Your Ref: 2021/91506
Our Ref: X007831

25th June 2021

Shop Lane, Kirkheaton, Huddersfield - Reserved matters application pursuant to outline permission 2014/92535 for erection of 48 dwellings, formation of access and associated infrastructure

TITLE		DRAINAGE FEASIBILITY	
PROJECT		SHOP LANE, KIRKHEATON	
CLIENT		HARTLEY PROPERTIES	
DRAWING STATUS		PRELIMINARY	
Scale	Date	Drawn	AT
1:500 @ A1	JAN 21	Chk.	MI
Drg. No.	0906/09/SK5		Rev C

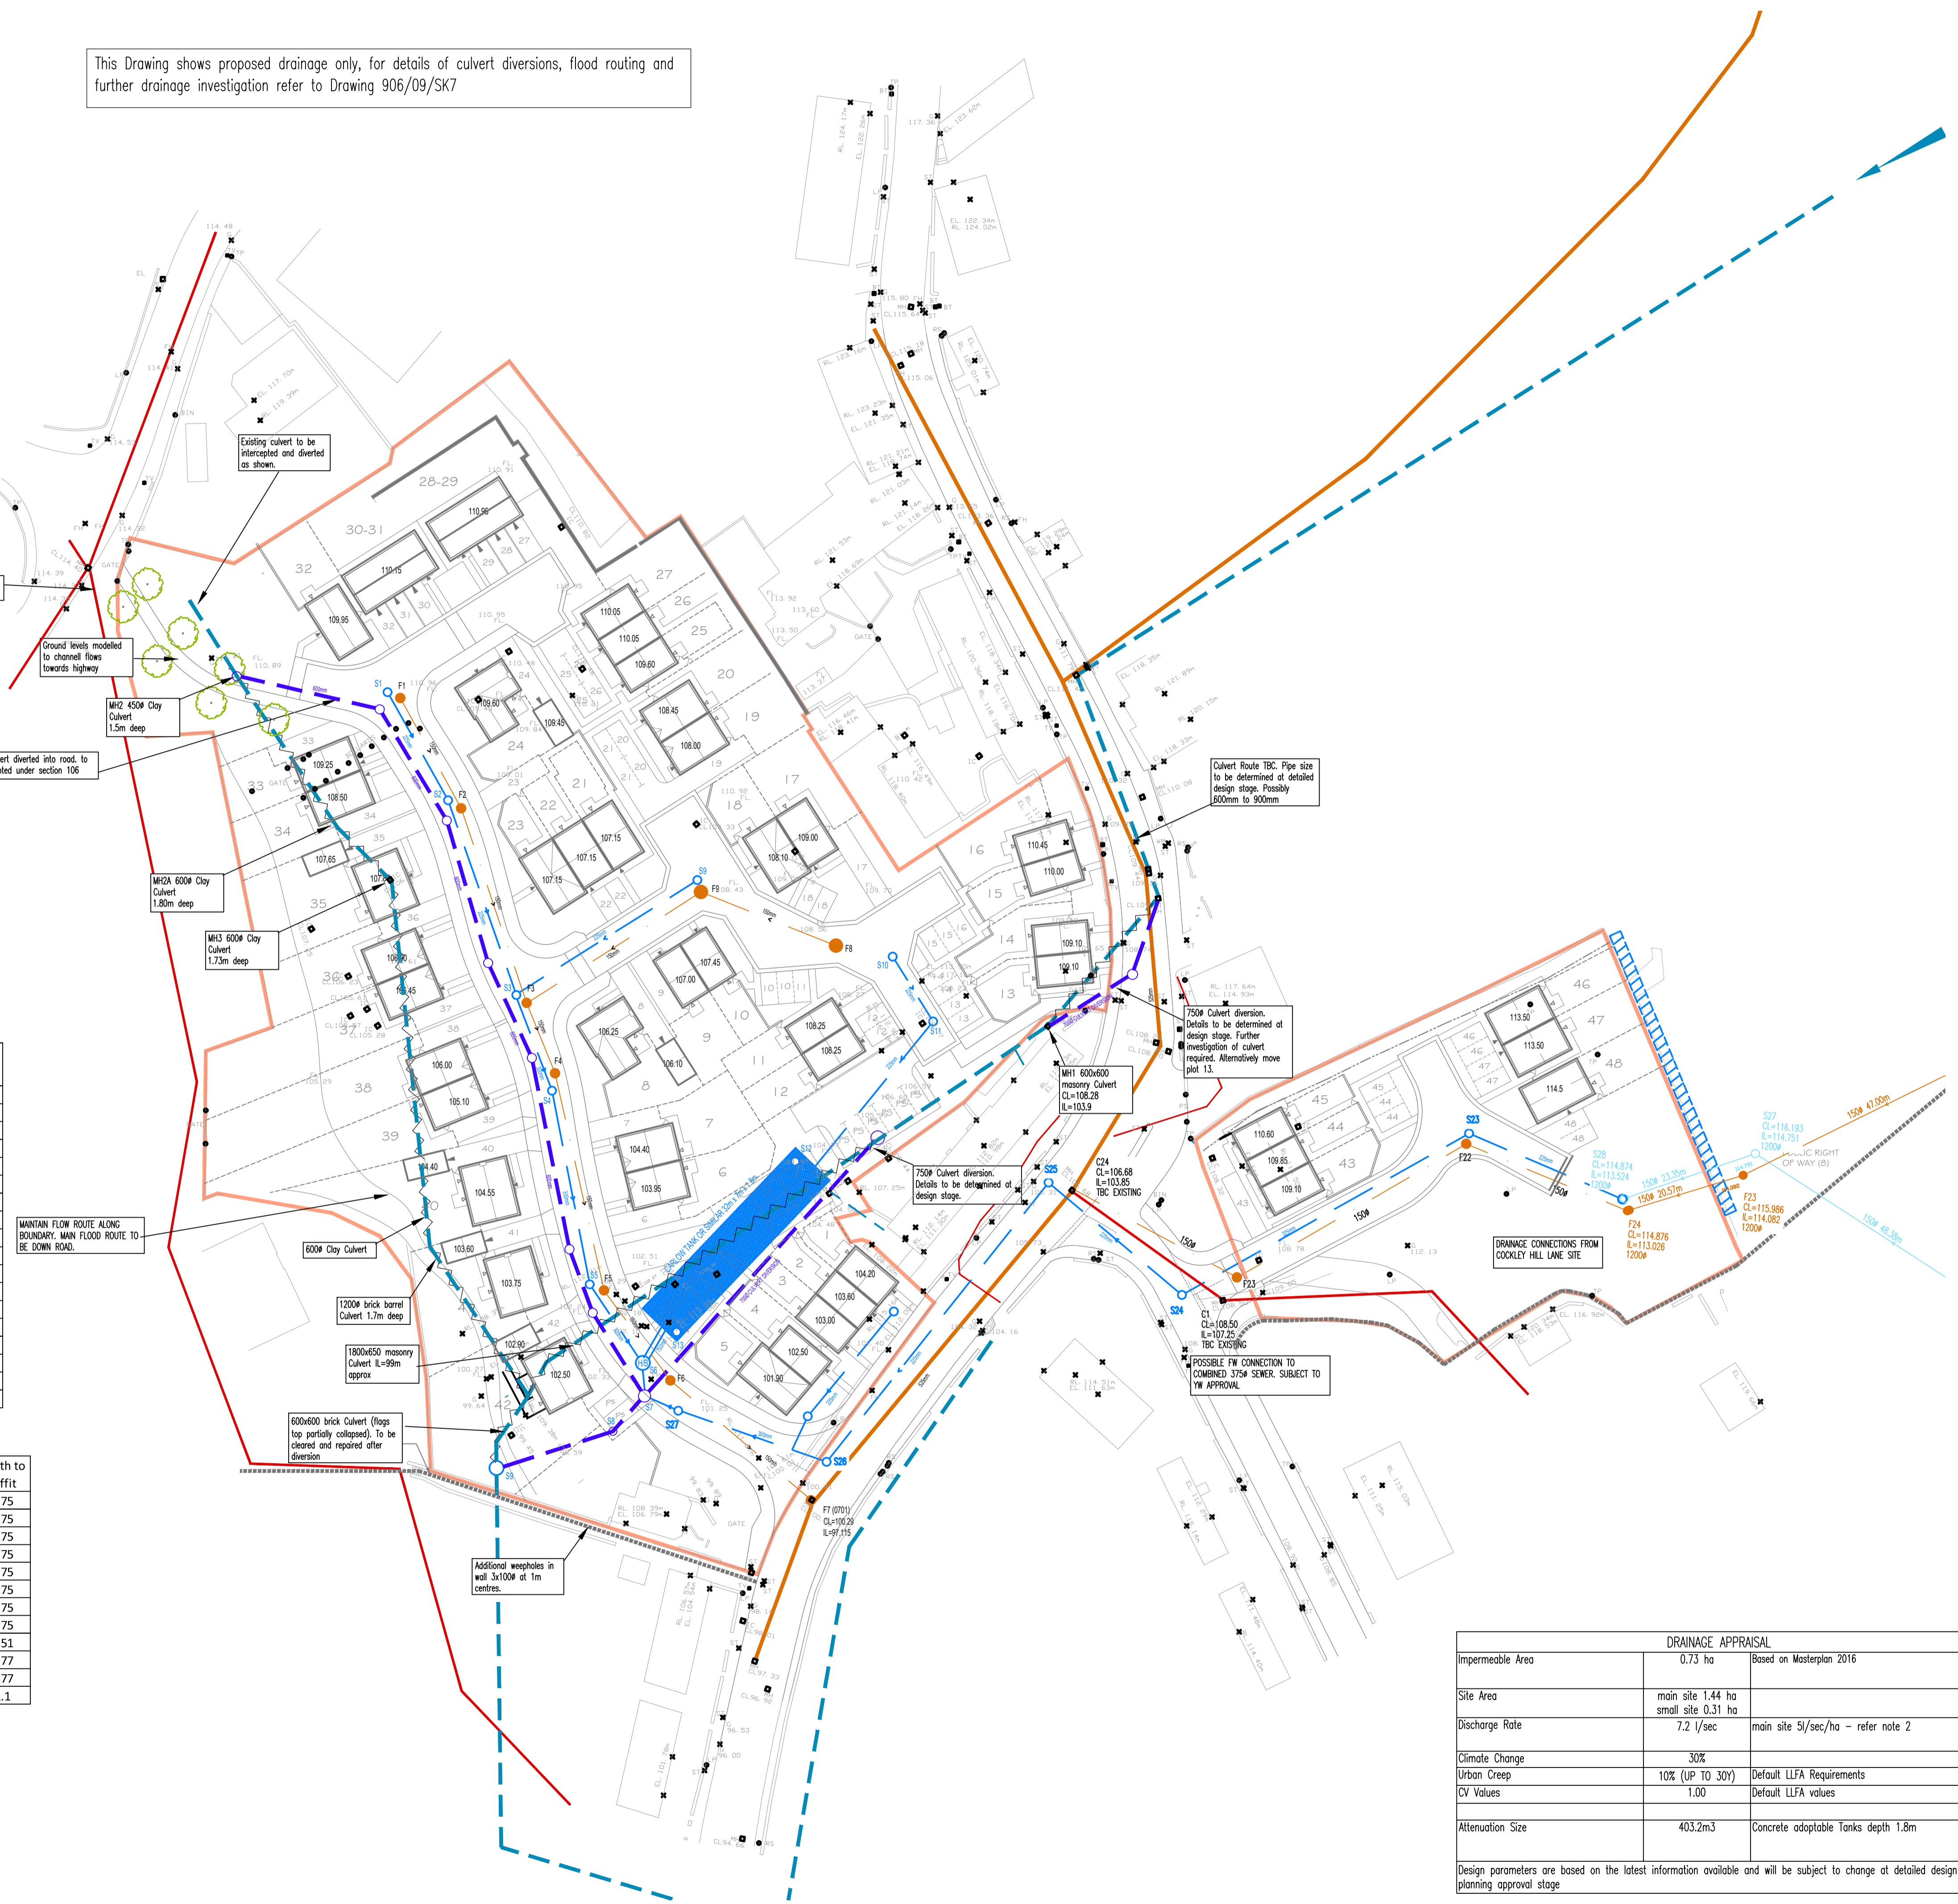
Yorkshire Water has no objection to the submitted on drawing 0906/09/SK5 (revision C) dated 23/03/2021 that has been prepared by ARP Consulting Engineers. In summary, the drawing indicates:

- a) the proposed separate systems of drainage on site and off site;
- b) the proposed amount of domestic foul water to be discharged to the public foul sewer network;
- c) the proposed point of discharge of foul water to the public foul sewer in Shop Lane; and
- d) that surface water will be drained to culverted watercourse, which we fully endorse.
